COMMUNITY DEVELOPMENT DEPARTMENT
501 Delta Avenue ♦ Marysville, WA 98270 ♦ (360) 363-8000

Re: PA23-005 – Creekside PRD – Technical Review 3
7808 40th Street, 7811 & 7715 40th Street NE, APNs 29050200100200,
29050200100300, and 29050200100400

MEMORANDUM

MEMORANDUM

**RD-01**  
SHEET 6 OF 15

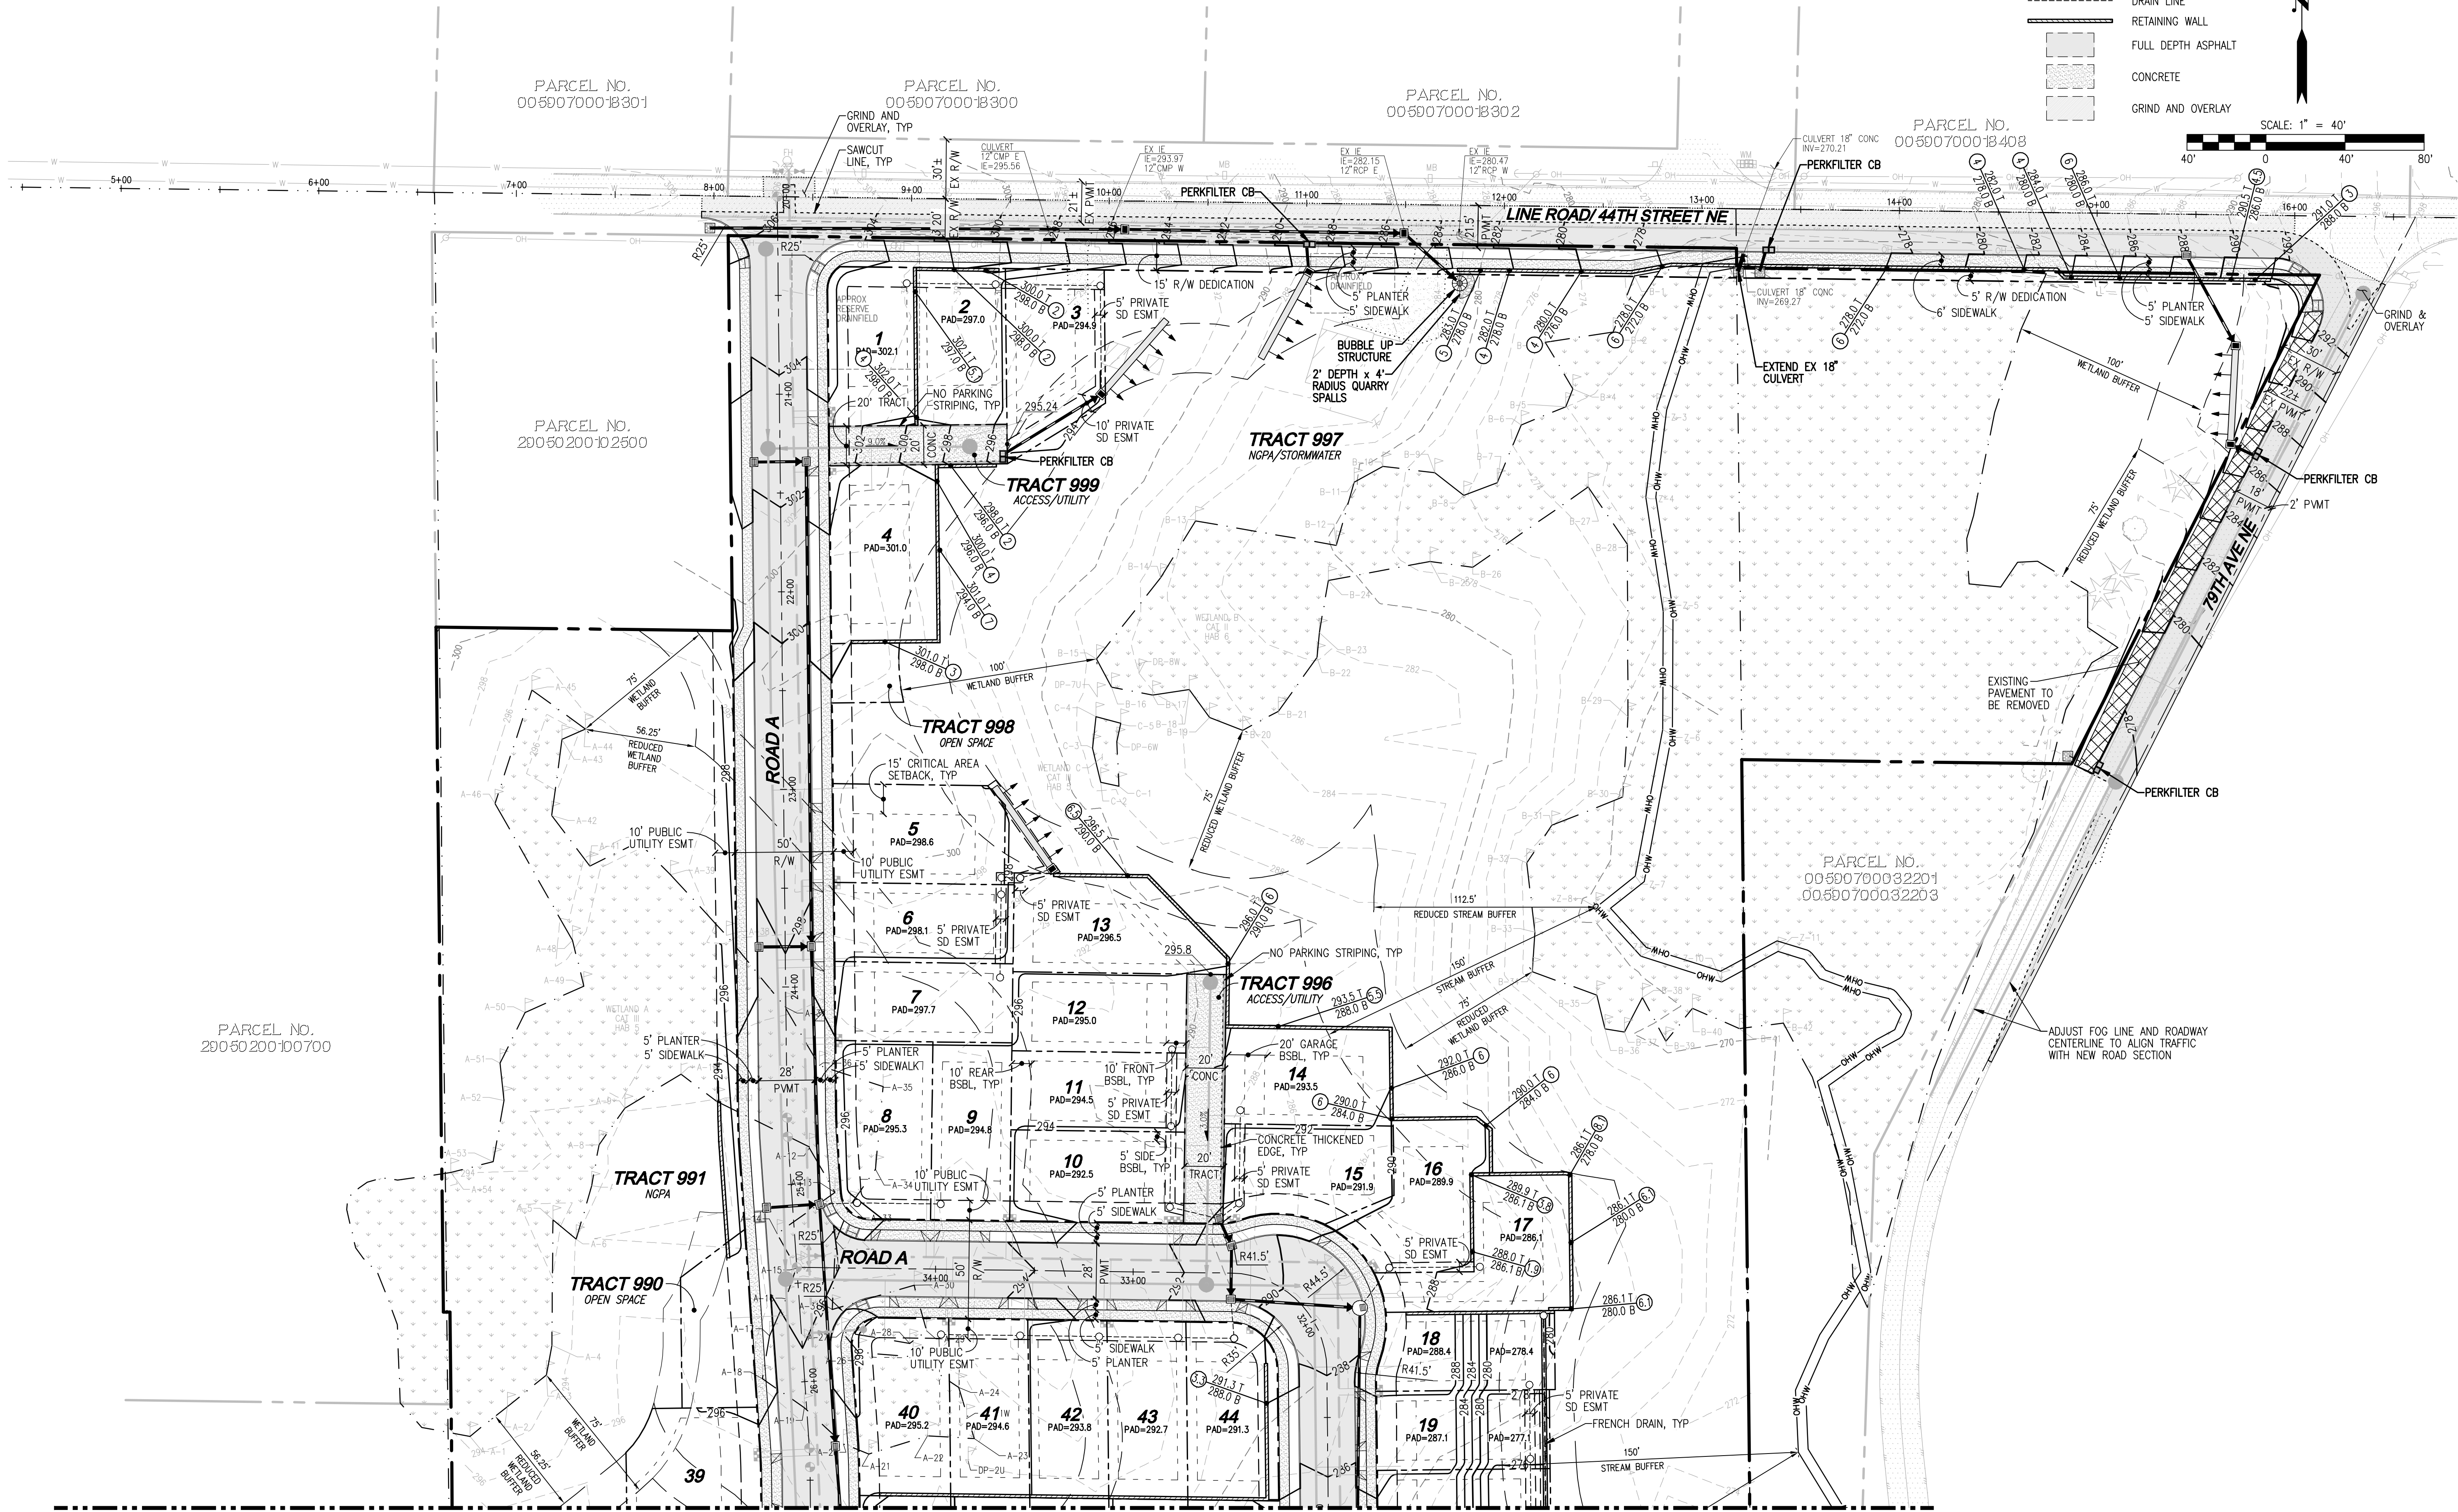
- 7) ADA Curb Ramps:
- a. ADA curb ramps shall be provided to cross all legs of all public roadway intersections.
 - i. Add curb ramps for south leg of Road A intersection near Lots 8 & 40.

- ii. Add curb ramps for east leg of Road A & Road B intersection near Lots 45 & 28.
 - iii. Add curb ramp(s) to cross east leg of 44th ST NE & Road A intersection.

- 1. Only curb ramp upon frontage required as north side of roadway is unimproved with no curb/gutter.
 - iv. If feasible for construction to parcel property line, construct all ADA curb ramps for intersection of 40th ST NE & Road B.

- iv. Parking restrictions, given challenges of sanitation pickup, shall be placed upon outside of all 90 degree curves within proposed development.
 - 1. Example = from west of Tract 996 access drive to south of Lot 18.

**RD-02**  
 SHEET 7 OF 15

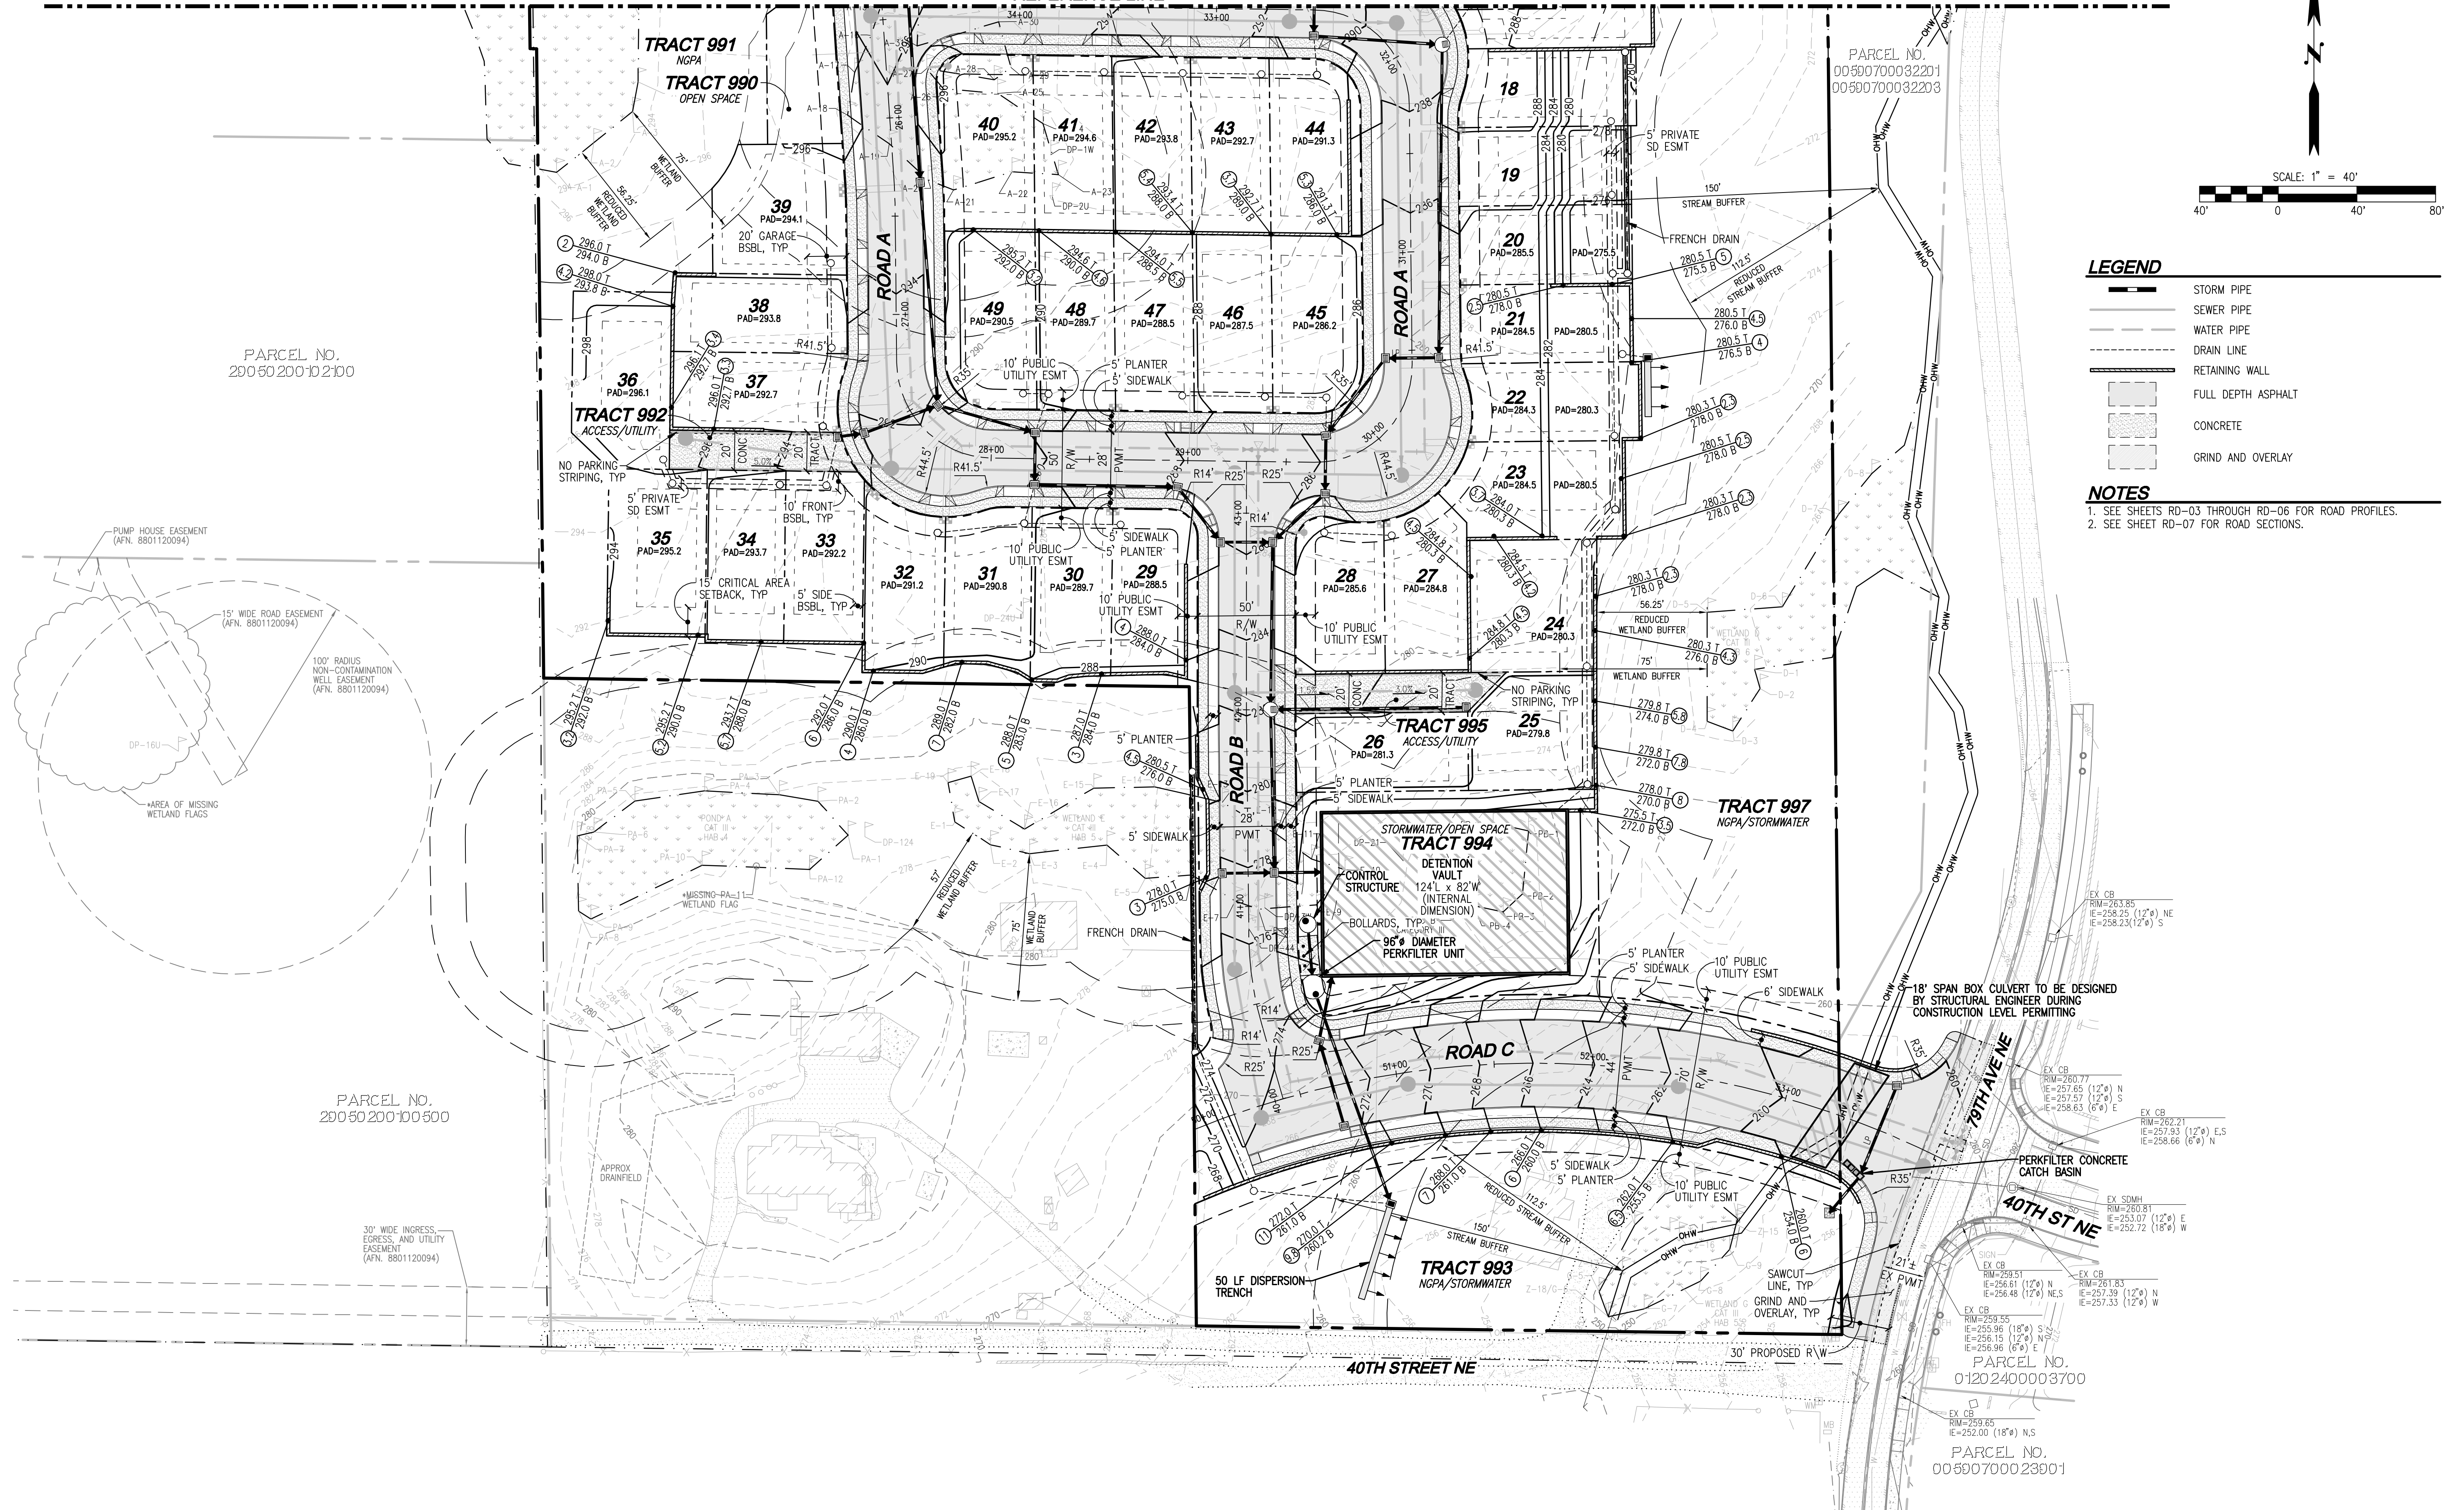
1. Please provide vehicle access for maintenance purposes to the stormwater facility (spreader bar) on Tract 993.
2. Please show stormwater facility features (access points, manholes, and vents) for the vault located on Tract 994 on the landscaping plans.

**ROAD C SECTION**  
SCALE: 1"=5'  
CITY OF MARYSVILLE STD PLAN 3-201-004

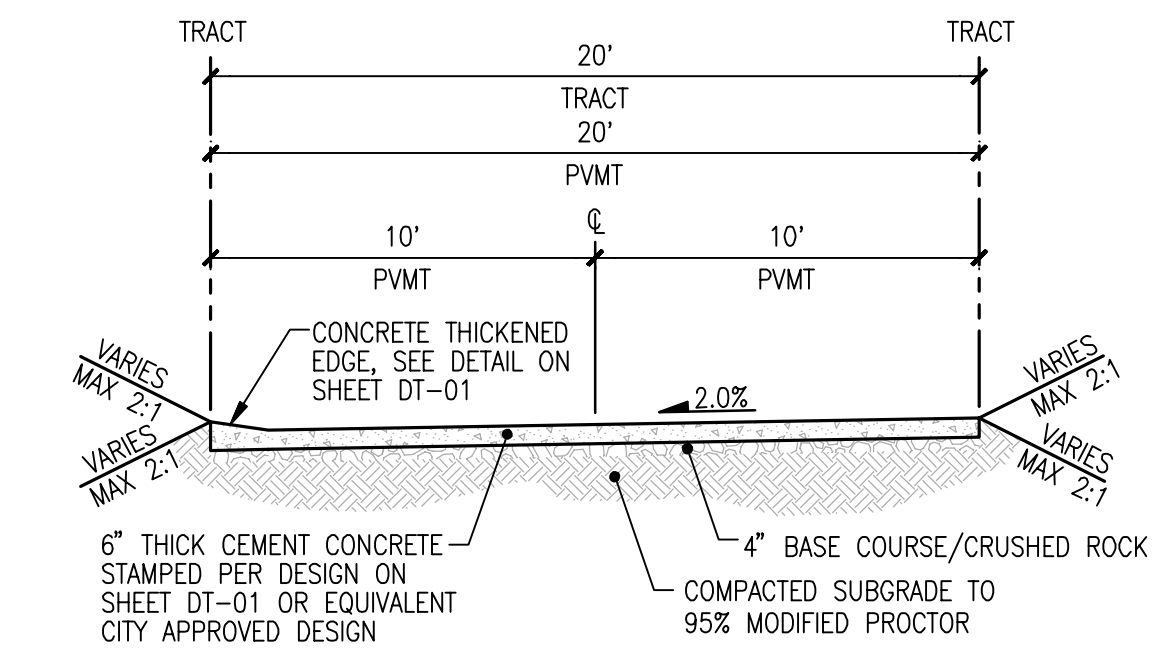
- 5) Per the Comprehensive Plan, 40th ST NE shall be extended west from 79th Ave NE towards 71st Ave NE.
 - a. Roadway cross-section shall be 70' ROW three lane roadway with bike lanes per EDDS Standard Plan 3-201-004.

- i. Indicate upon cross-section, all roadway lane designations with dimensions.
 - b. Roadway shall be constructed to parcel line unless not feasible due to vertical/elevations of roadway with adjacent parcel.
